RE: REVISED DRAINAGE PLAN FOR AN ADDITION TO HELWEG & FARMER
TRANSPORTATION CO. (L20-D53) REVISION DATED 6/21/94.

RE: DRAINAGE PLAN FOR AN ADDITION TO HELWEG & FARMER TRANSPORTATION CO.
(L20-D53) ENGINEER'S STAMP DATED 6/9/94.

Based on the information provided on your June 10, 1994 submittal, listed are some concerns that will need to be addressed prior to final approval:

**DRAINAGE AND GRADING PLAN** C-1 Sh. 1 of 1

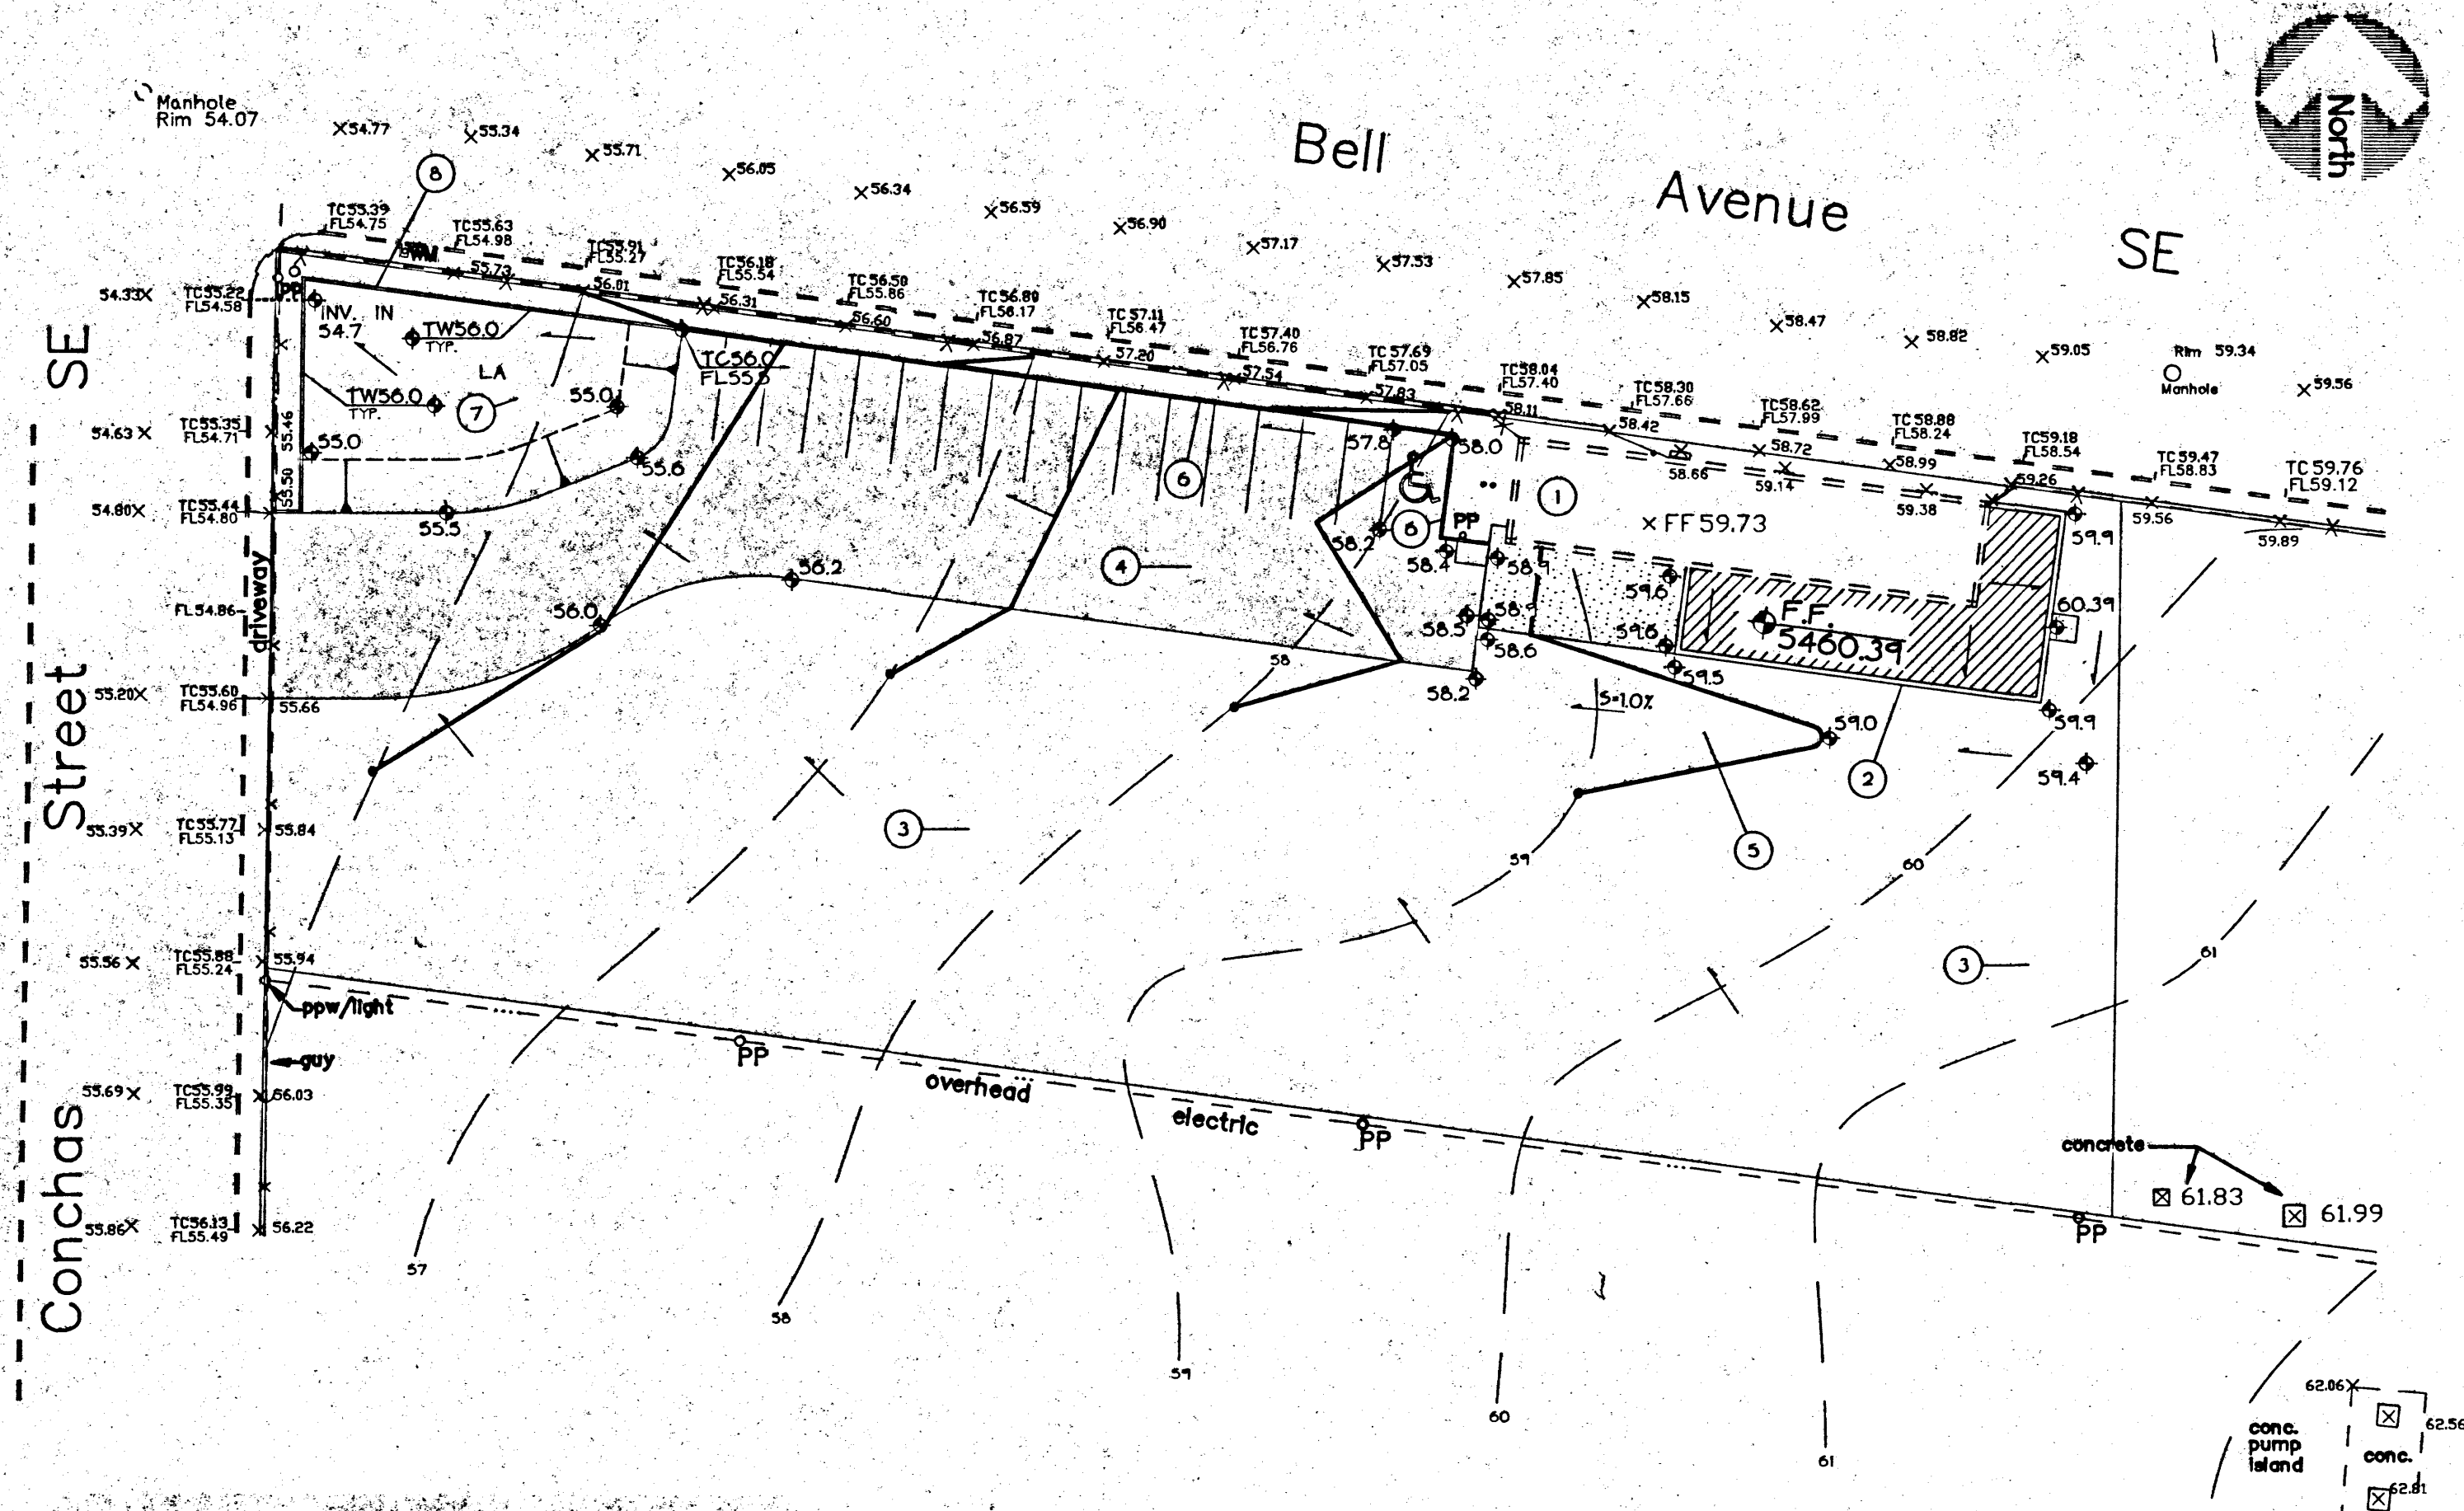
- ✓ 1. Sign-off block and six notes from S.O. 19 format required on plan drawing.
- ✓ 2. What type of sediment control is proposed within the ponding area?
3. Specify the C.O.A. Spec. No. on the plan drawing for the 4" pvc penetration through the curb.
4. Two copies of plan drawing with submittal.
